Case Officer: Laura Bell

Recommendation: Approve

Applicant: Albion Land

Proposal: Vary the list of approved plans set out in Condition 2 to alter Unit 4's loading door arrangements to accommodate the operations of tenants (proposed as non-material amendment to 21/03177/F)

Drawing Title:  
UNIT 4 FLOOR PLANS

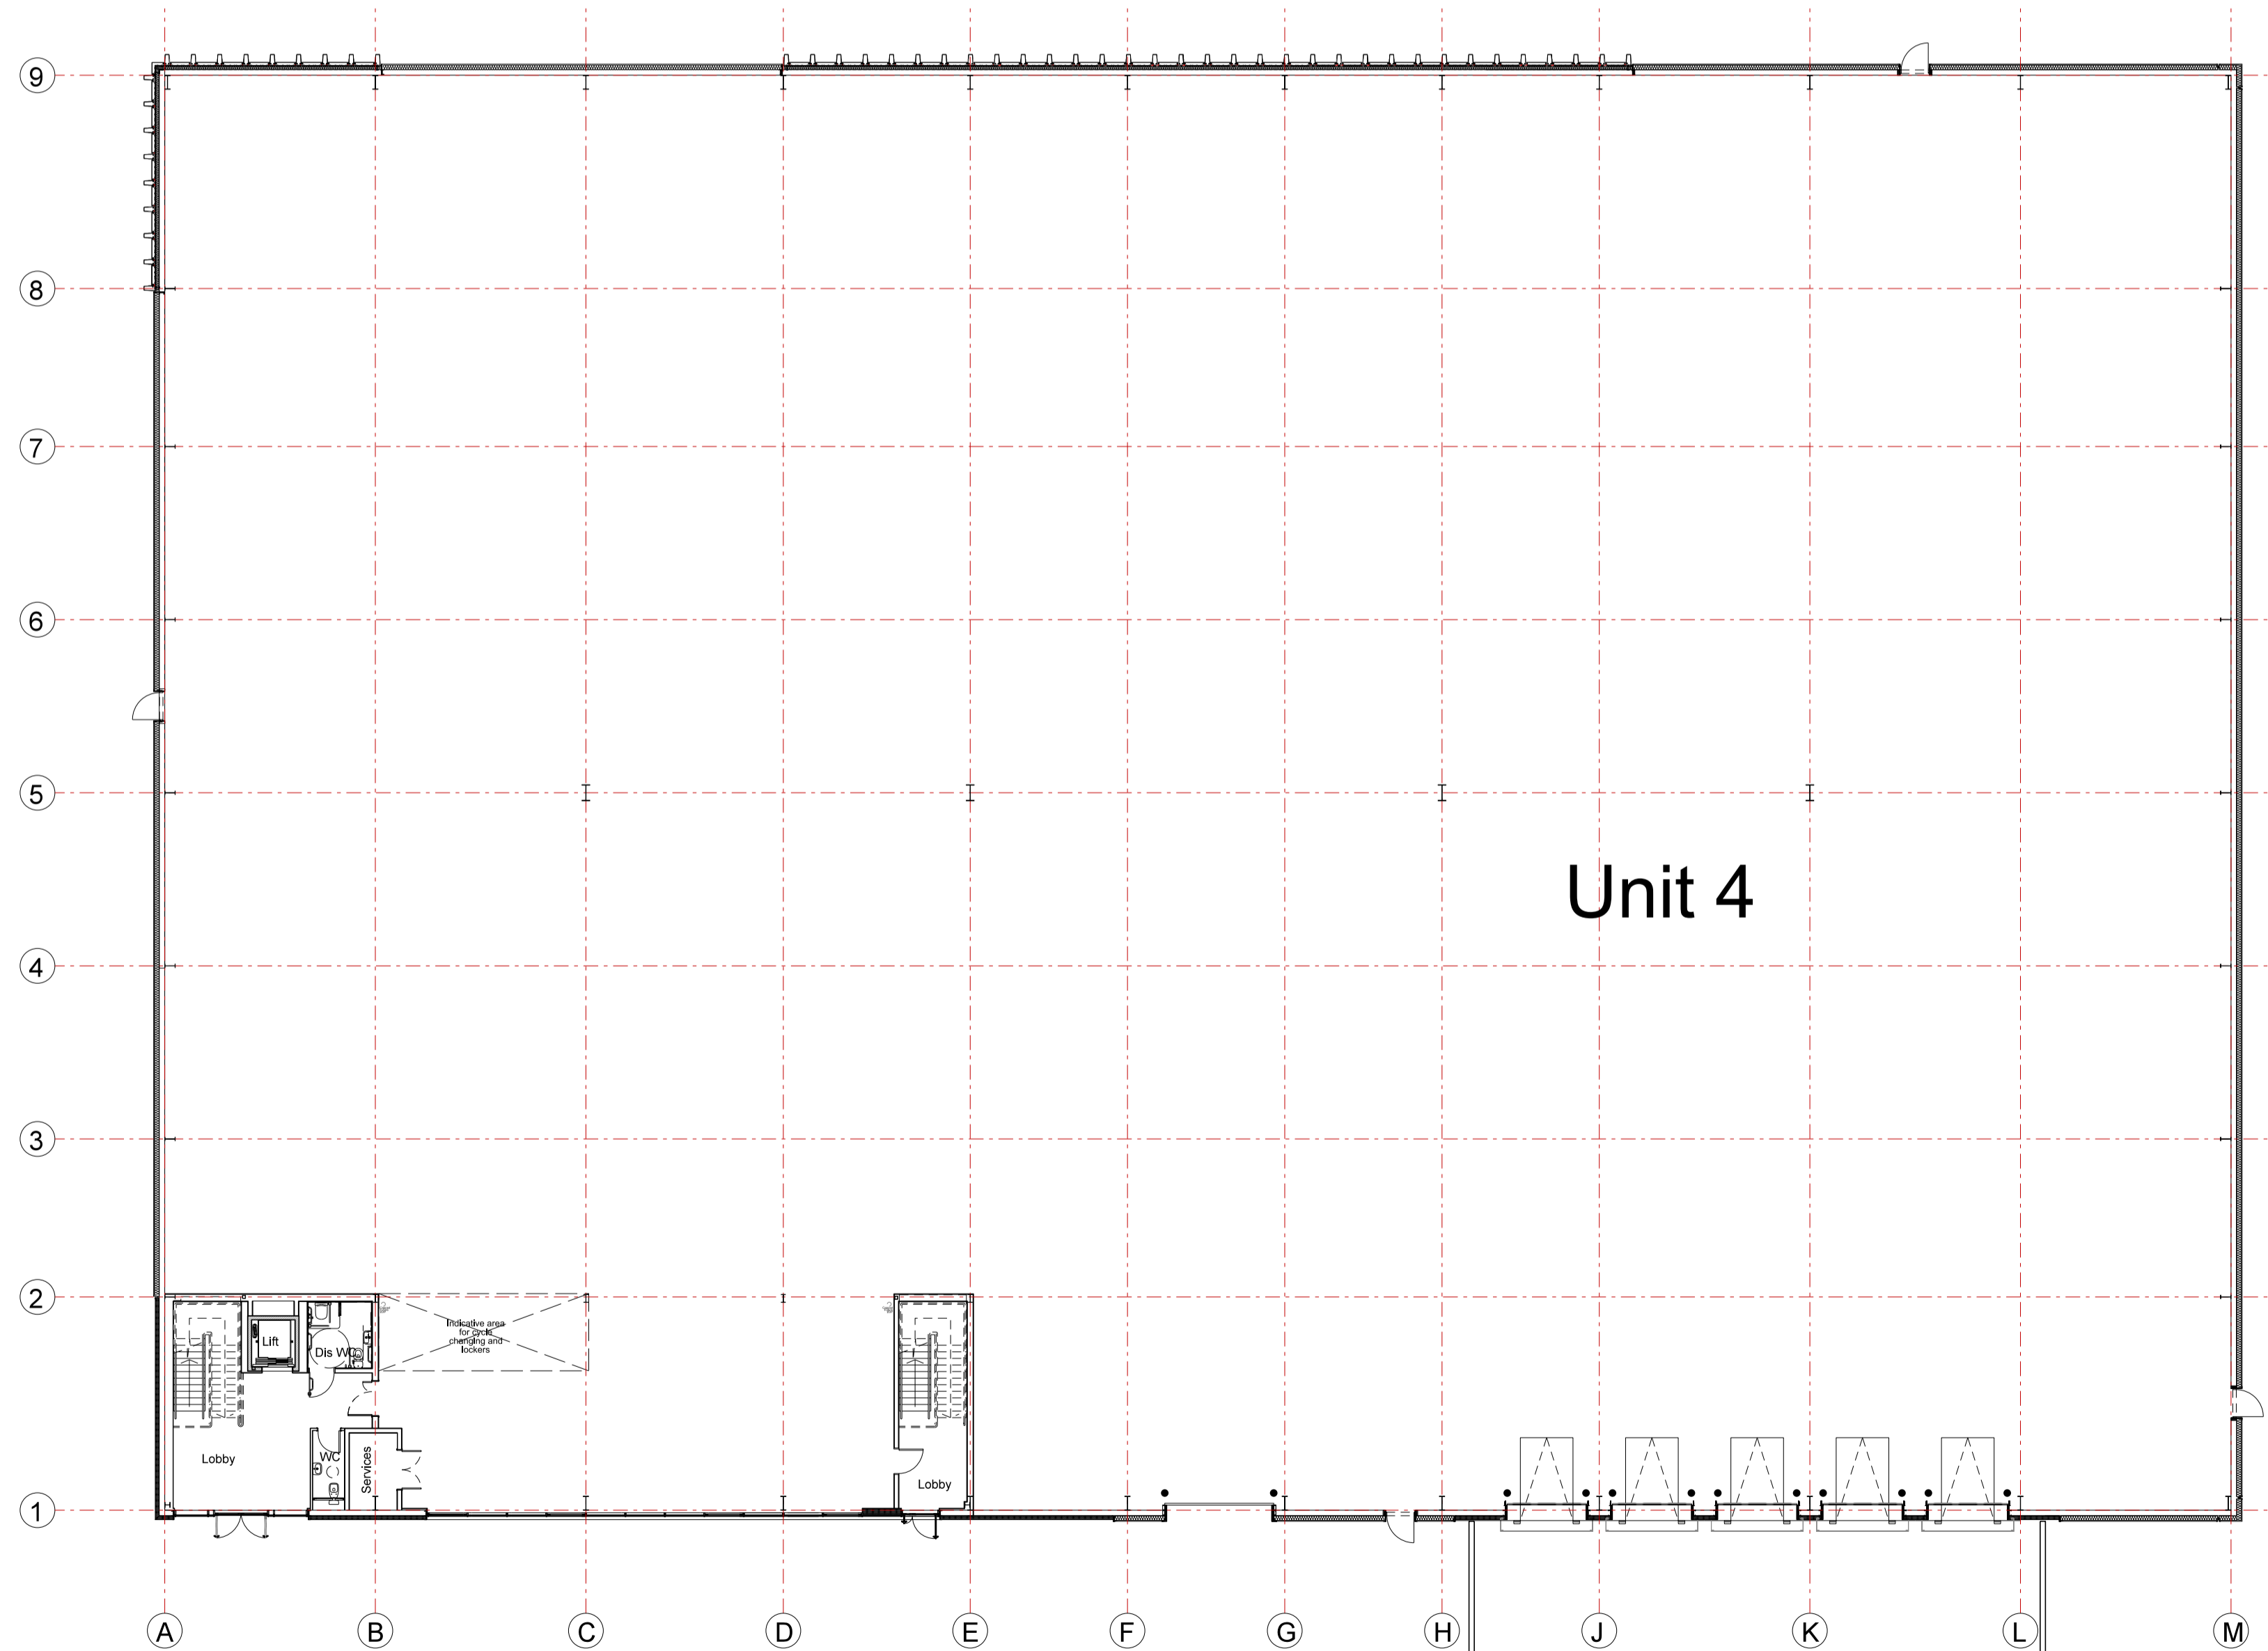
- 2.1. A non material amendment is sought to facilitate the operations of the new tenants. The changes involve minor alterations to the current loading arrangements and slightly alter the layout of the service yard. The changes have also resulted in minor changes to one external elevation.

- 5.4. The changes to the layout of the service yard do not adversely impact upon HGV tracking nor on parking provision within the site. The changes to the south west elevation are minor and remain consistent with the elevational detailing of other units.
